CITY OF ALBUQUERQUE

**Re: 4 Unit Townhouse Development
1203 Griegos Rd NW
Request Permanent C.O. - Accepted
Engineer's Stamp dated: 3-22-15 (F14D070)
Certification dated: 2-3-16**

**Re: 4 Unit Townhouse
1203 Griegos Rd. NW
Grading & Drainage Plan
Engineer's Stamp dated: 3-22-15 (F14D070).**

**Re: 4 Unit Townhouse Development
1203 Griegos Rd NW
Grading & Drainage Plan
Engineer's Stamp dated: 3-05-15 (F14D070)**

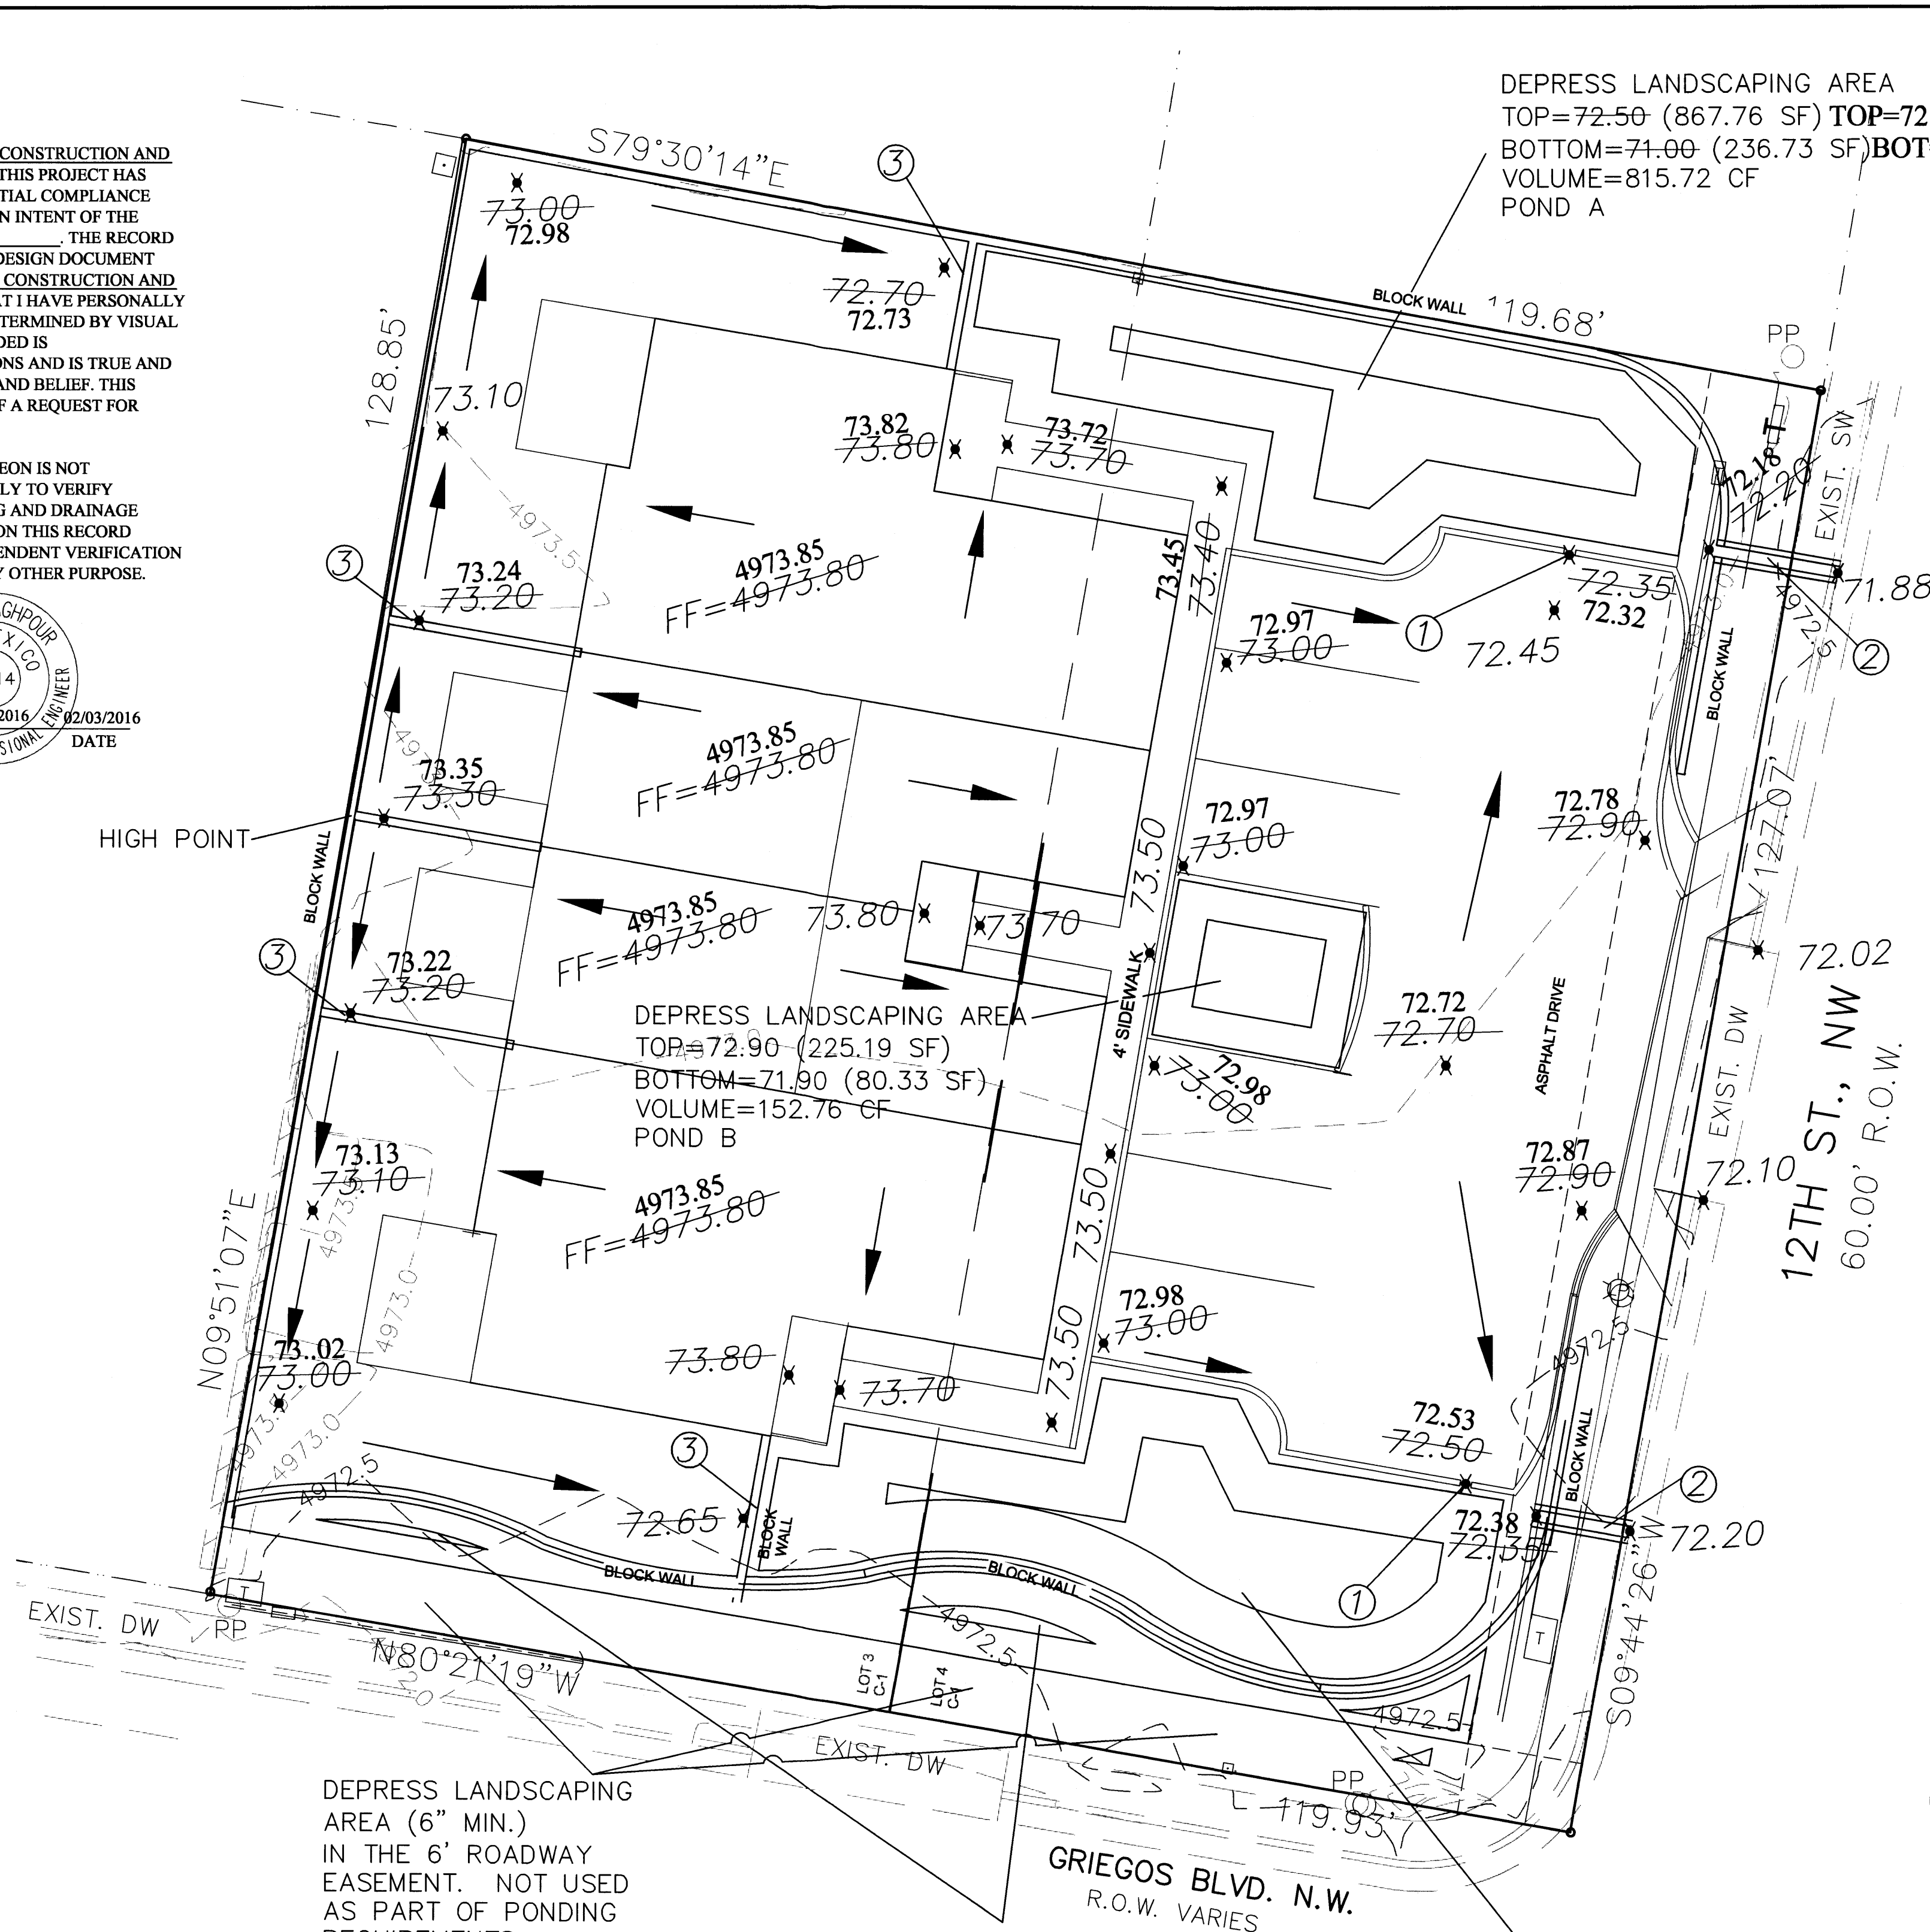
- ✓1. In the Valley (the area between the Rio Grande and Broadway), the volume required for a retention pond is 0.5 inch multiplied by the area of the site. Include a Water Surface Elevation for each pond. This will reduce the size of the ponds significantly. (Also note, for detention in the Valley, the allowable discharge is a maximum of 2.75 cfs/acre.)

- ✓2. Although retention has been provided, the First Flush still needs to be discussed. Per the City Drainage ordinance, the 90th Percentile Storm Event, which is 44 inches, is to be managed. Reduce 0.44 inch by the 0.1 inch for the initial impervious abstraction in Table A-6 of Section 22 of the DPM. Multiply the remaining 0.34 inch by your impervious area. This is the amount of the First Flush necessary for the site. Show that amount on your plans. State that the capacity provided by the retention pond is greater than what is required for the First Flush.

- ✓3. The Grading and Drainage plan should match the site plan. The site plan submitted to DRB has two islands in the parking lot, but the Grading and Drainage plan only has one. *ALSO 6 UNITS & 4 UNITS MATCHES ONE NOW PROVIDED*

- ✓4. Two sidewalk culverts are called out that are in the public ROW. Provide SO-19 language and signature block on the plan which is attached. Request SO-19 review on the DTIS.

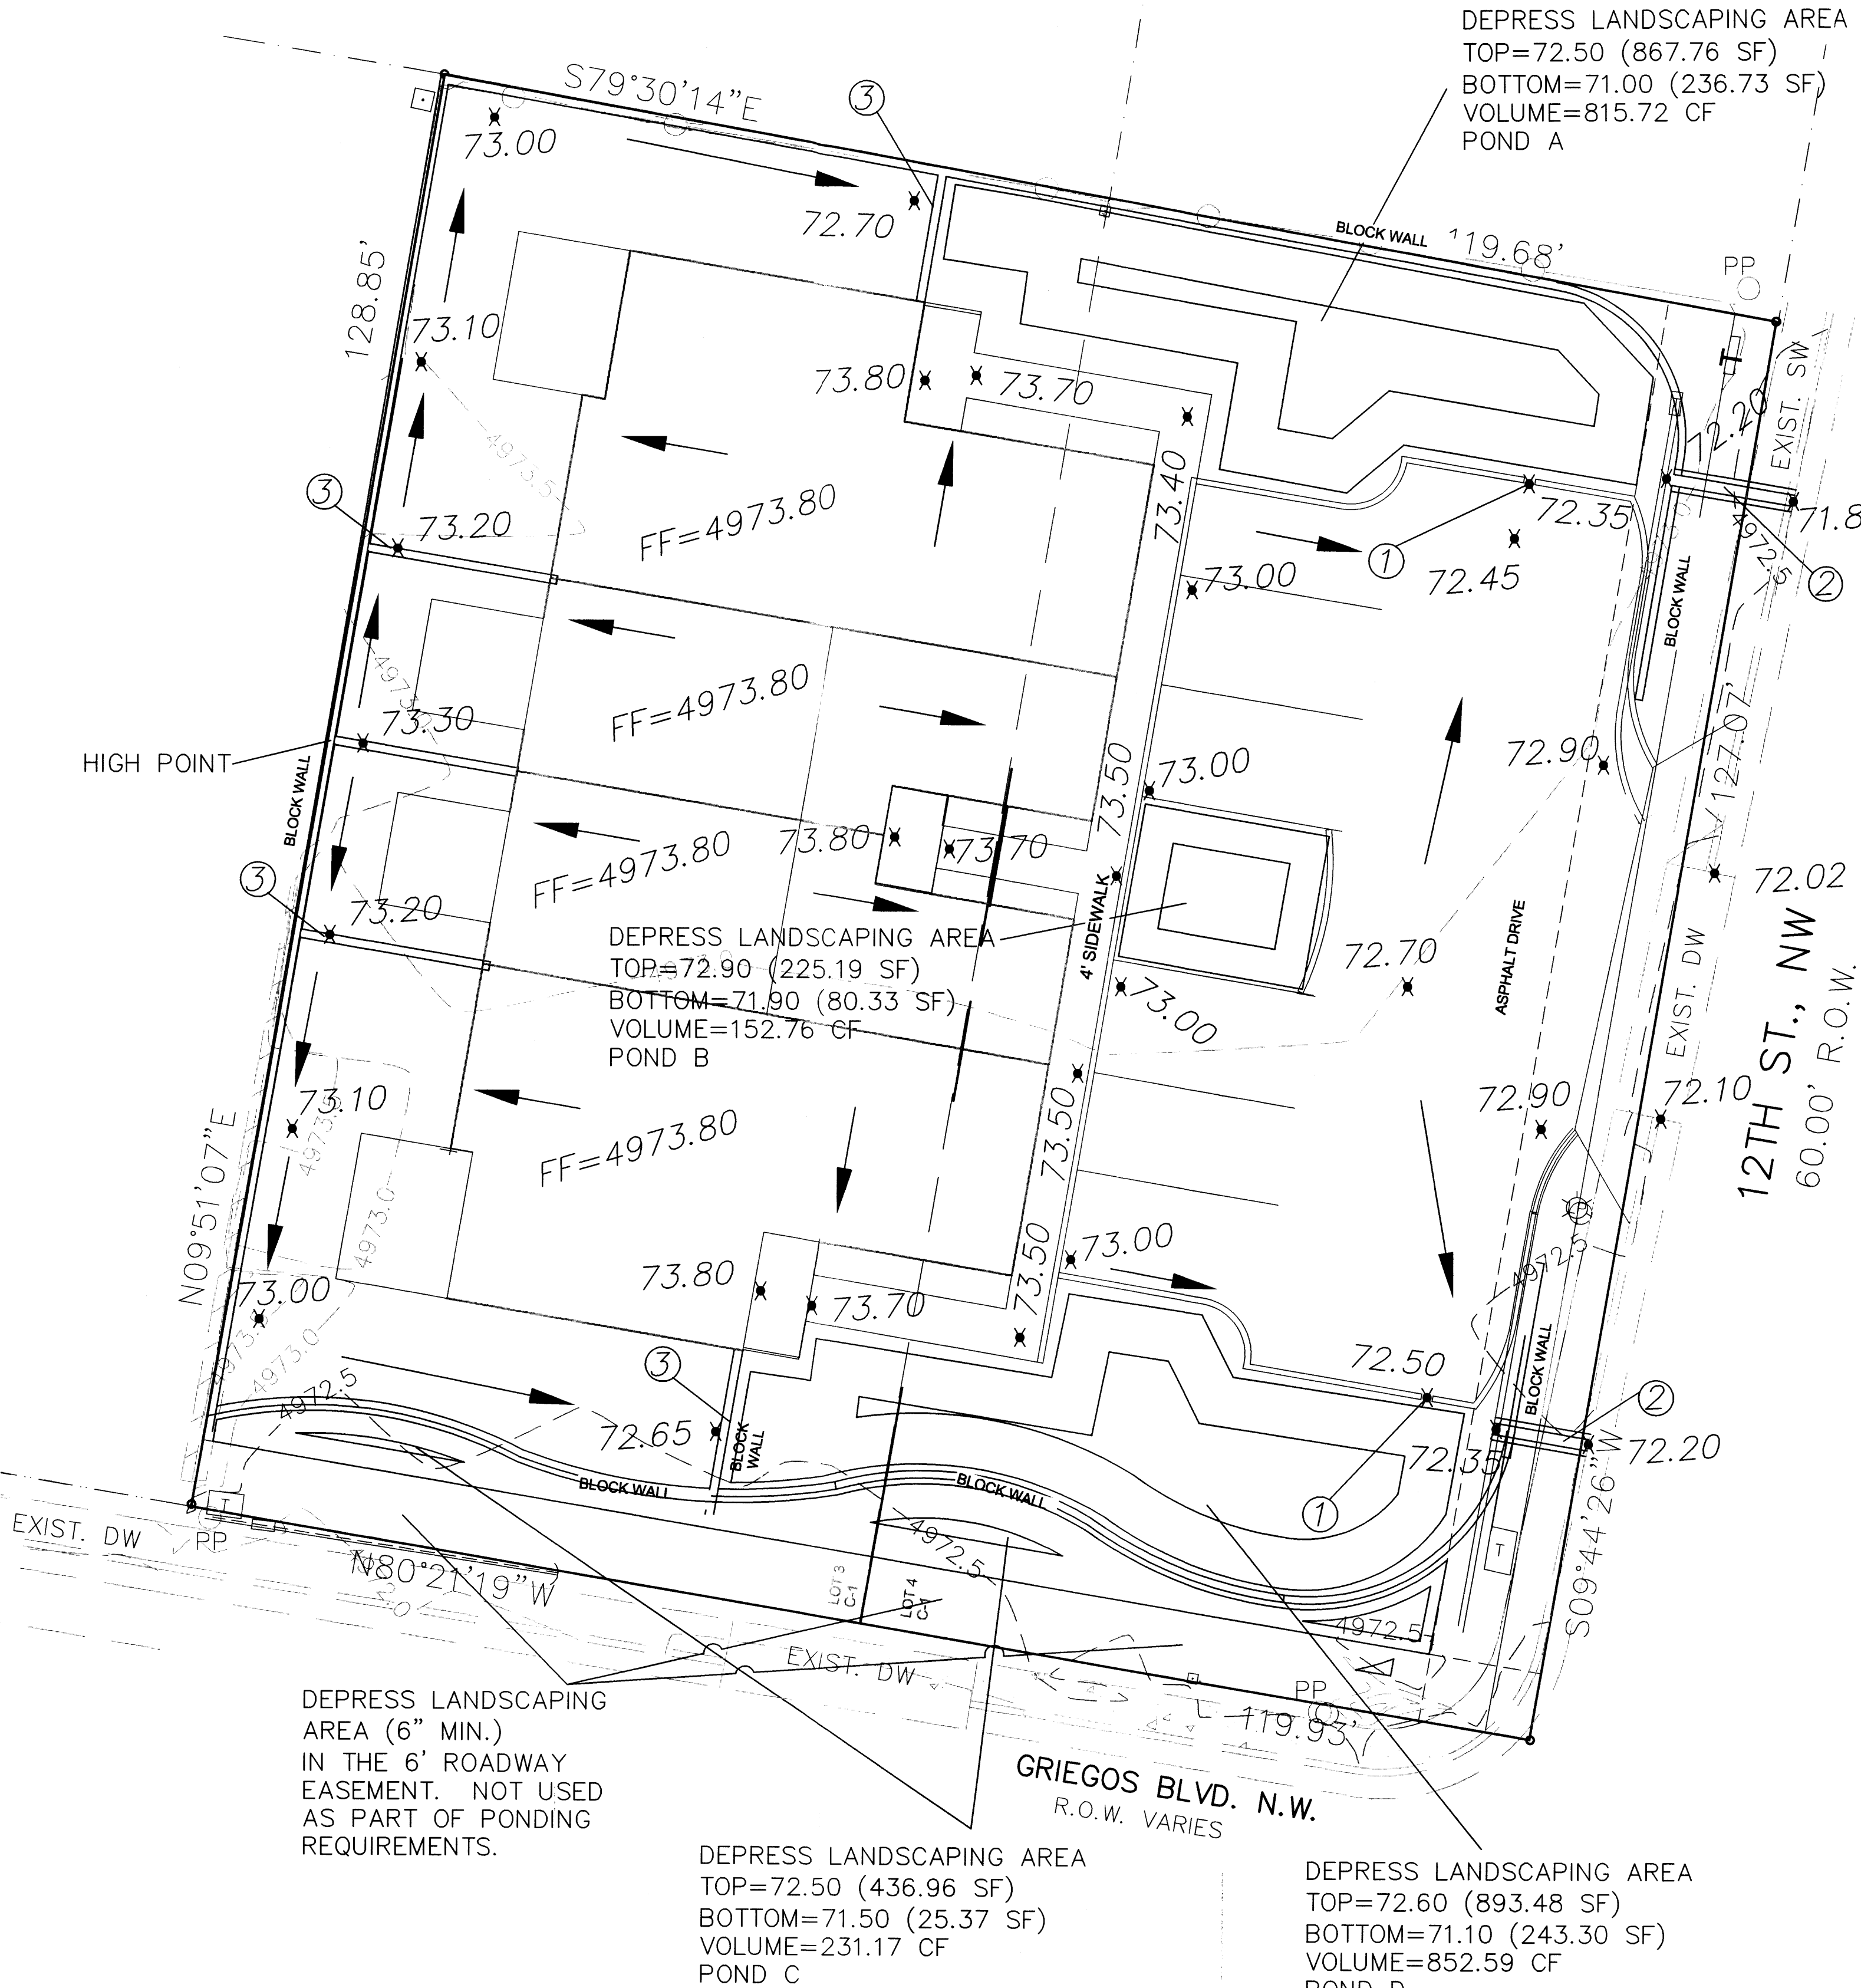
- Provide direction of roof flows. If flows are toward the front, how will these flows enter the ponding areas?
- Consider building #4 rebar spaced at three 3" on center to the wall openings.
- Move both sidewalk culverts closer to ponding areas. As they currently sit, it appears as though the flows from the parking lot will leave the site without entering the ponds for first flush requirements.
- Provide flow line spot elevations in 12th St. at entrance.
